DRB Application No.: 07DRB-70211 (P&F)
Project Name: **SUSIE RAYOS MARMON ELEMENTARY SCHOOL**
Agent: HIGH MESA CONSULTING GROUP

Project # **1005590**
Phone No.: 345-4250

**CITY OF ALBUQUERQUE
PLANNING DEPARTMENT
September 5, 2007
DRB Comments**

RE: Tracts A & B, Susie Rayos Marmon Elementary School/plat

PLAT OF
TRACT A-1
SUSIE RAYOS MARMON ELEMENTARY SCHOOL
ALBUQUERQUE, BERNALILLO COUNTY, NEW MEXICO
JULY, 2007

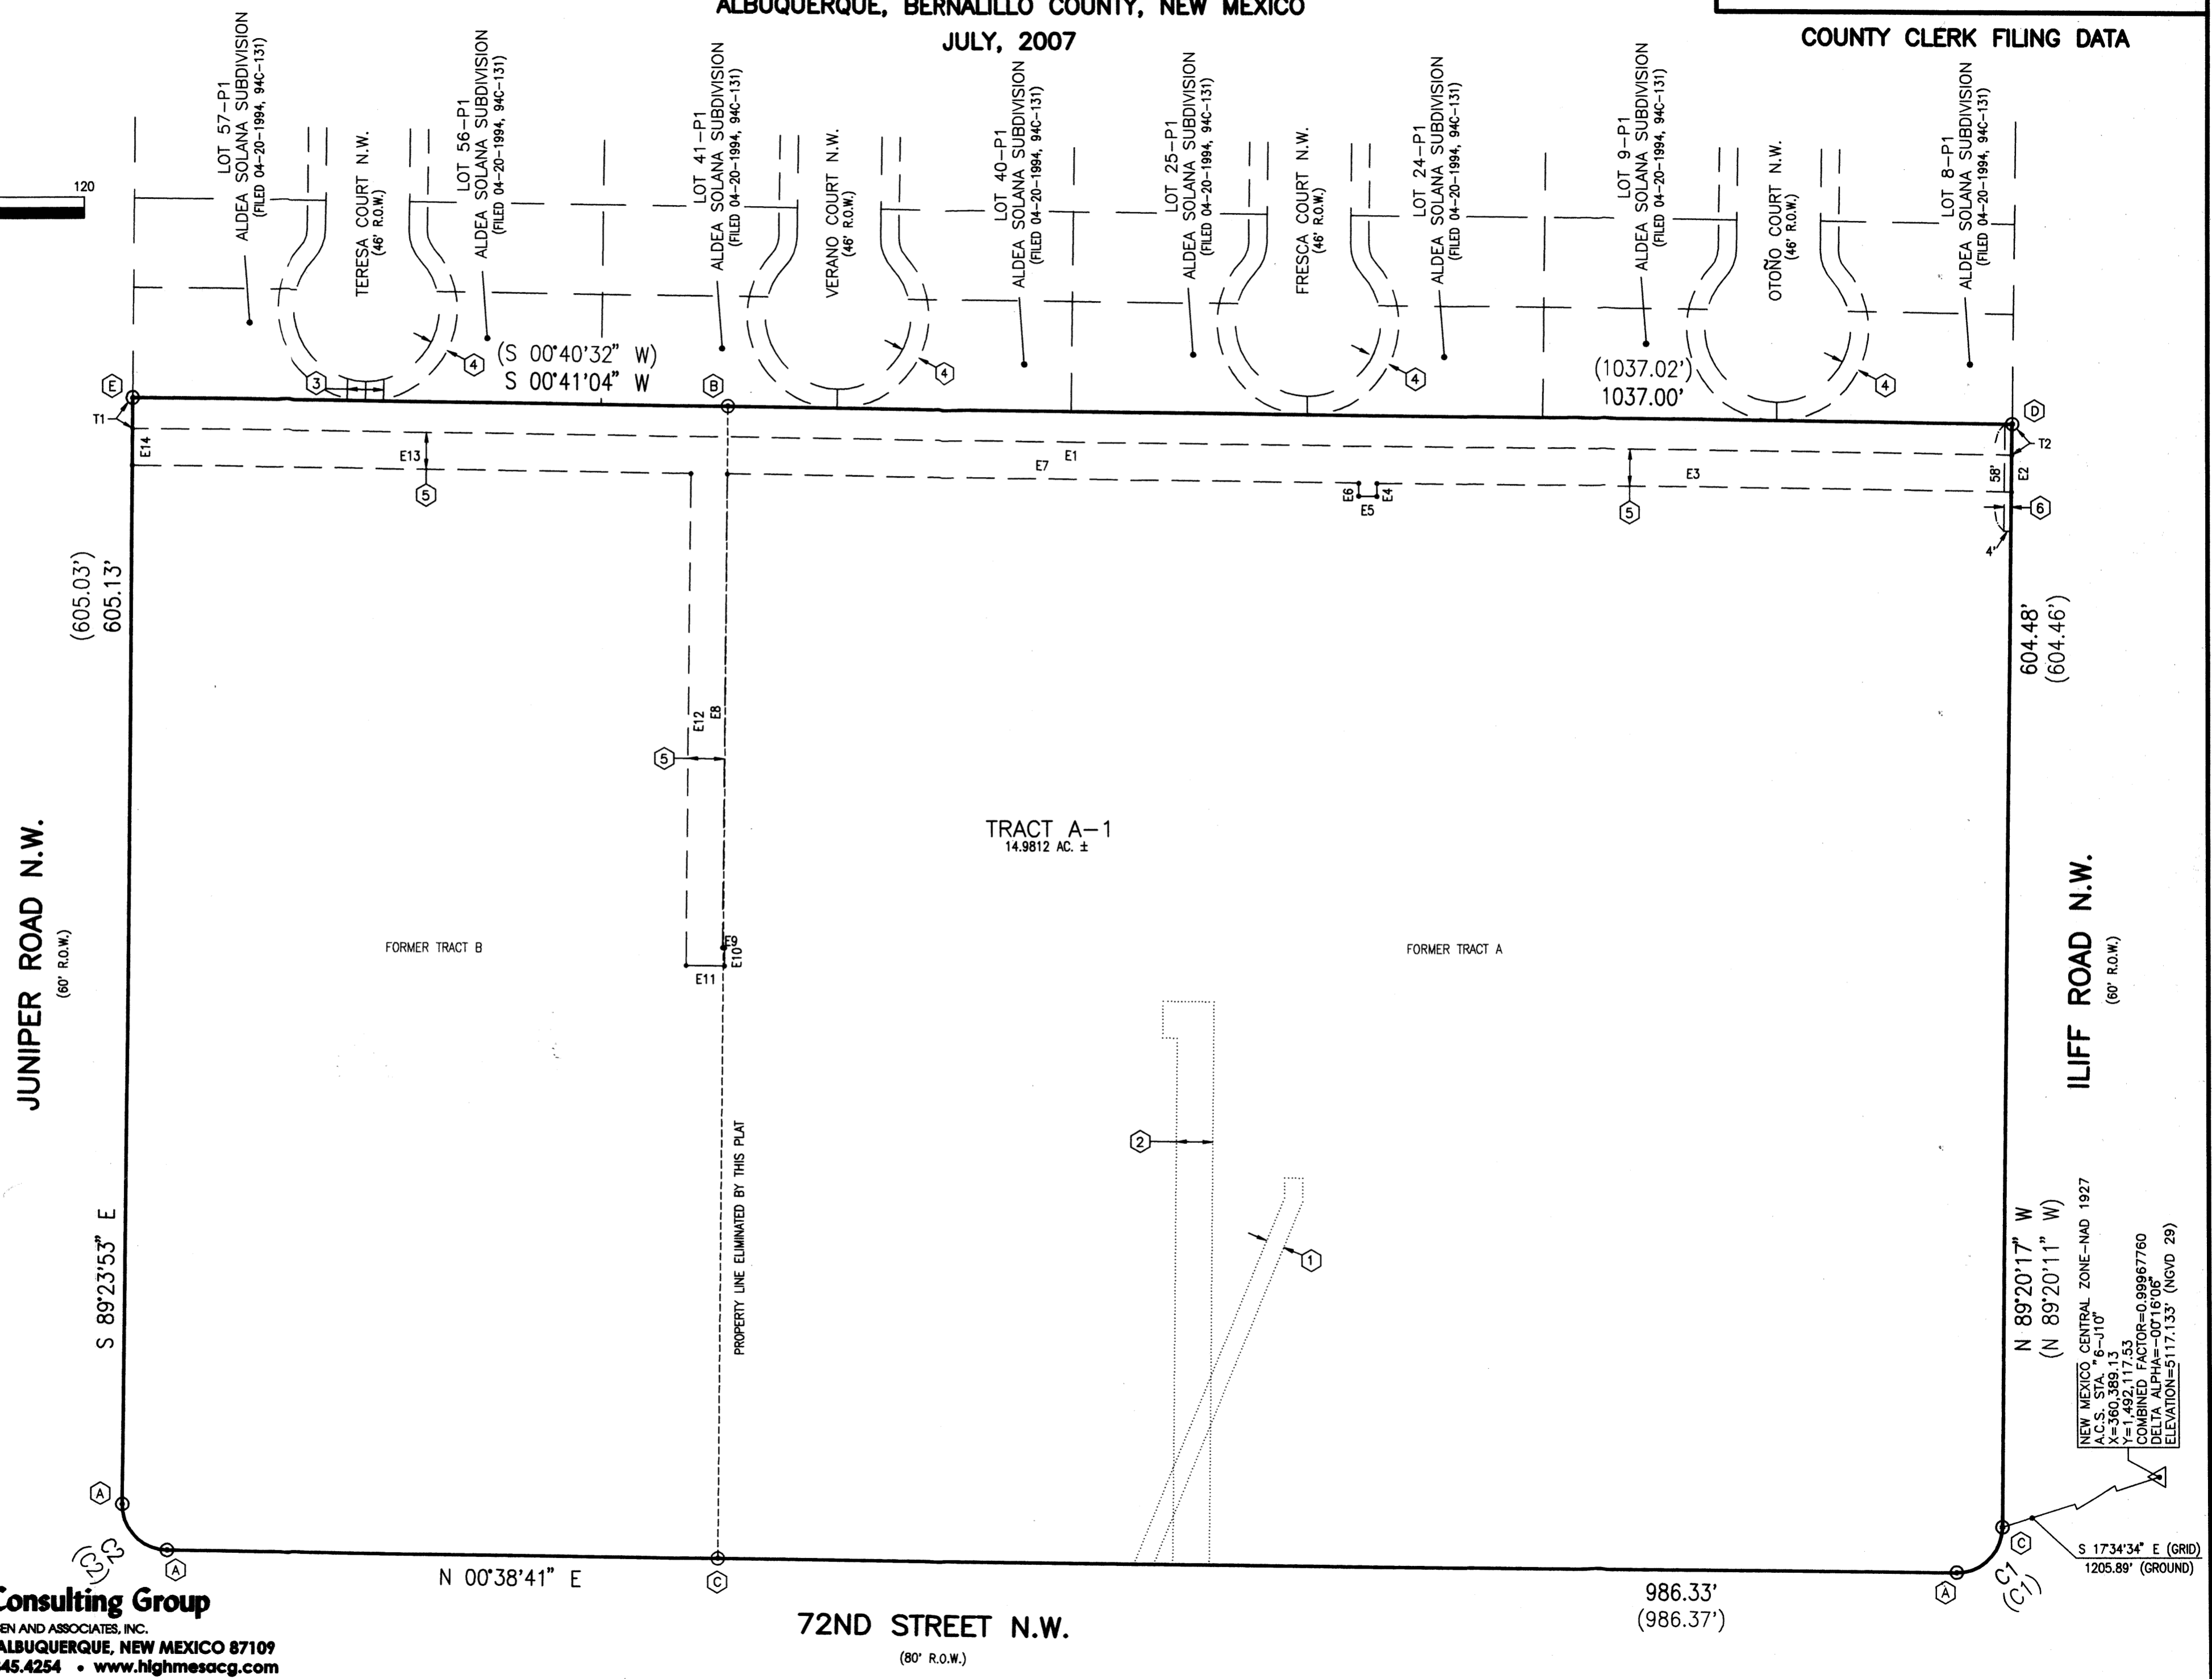
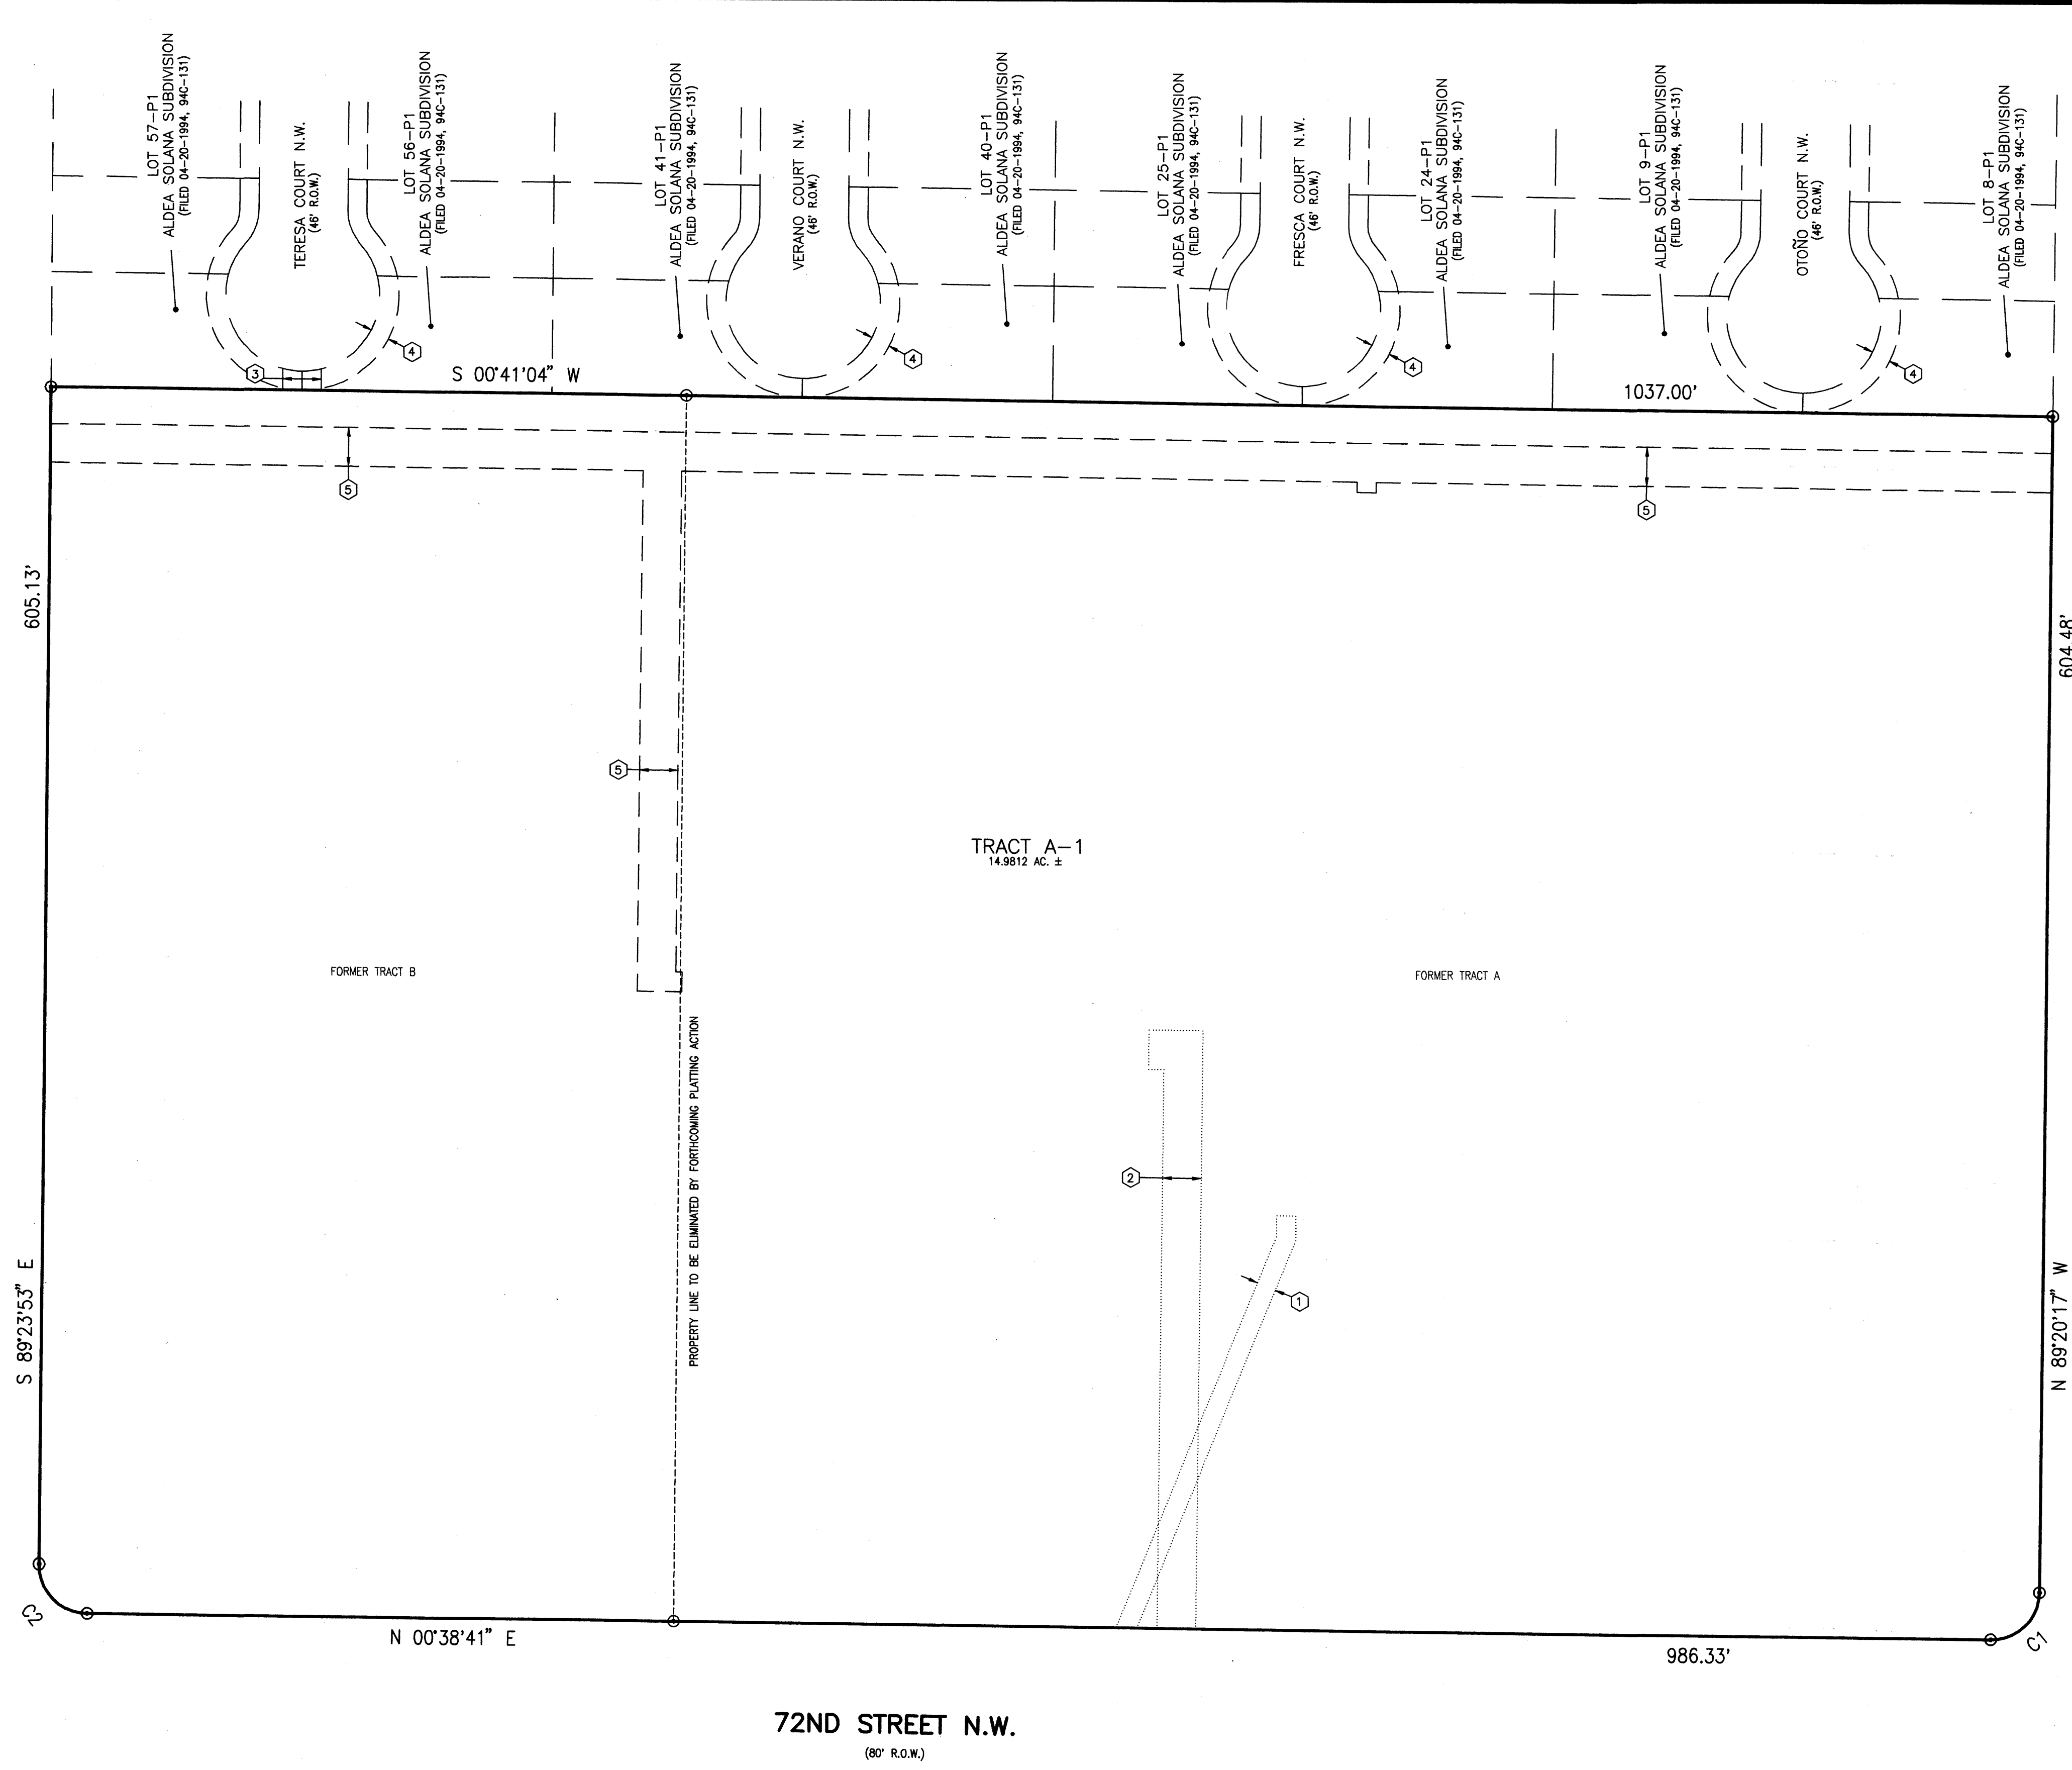
You show the tie to ACS 6-J10 (S17°34'34"E - 1205.89') from the PC of the curve "C1" on Iliff Road NW.

This tie actually runs from the PT of the curve on 72nd Street NW.

The bearing/distance works fine, just from the other end of the curve.

Can you verify this and let me know if you change the bearing/distance from the PC or if you just change the leader line from the PC to the PT?

Be advised that any plats approved by DRB must contain the following language from the City Subdivision Ordinance:

Section 14-14-4-7(B) "No property within the area of requested final action shall at any time be subject to a deed restriction, covenant, or building agreement prohibiting solar collectors from being installed on buildings or erected on the lots or parcels within the area of proposed plat. The foregoing requirement shall be a condition to approval of this plat or site development plan for subdivision."

Once this language is added, Planning has no objection to the requested replat.
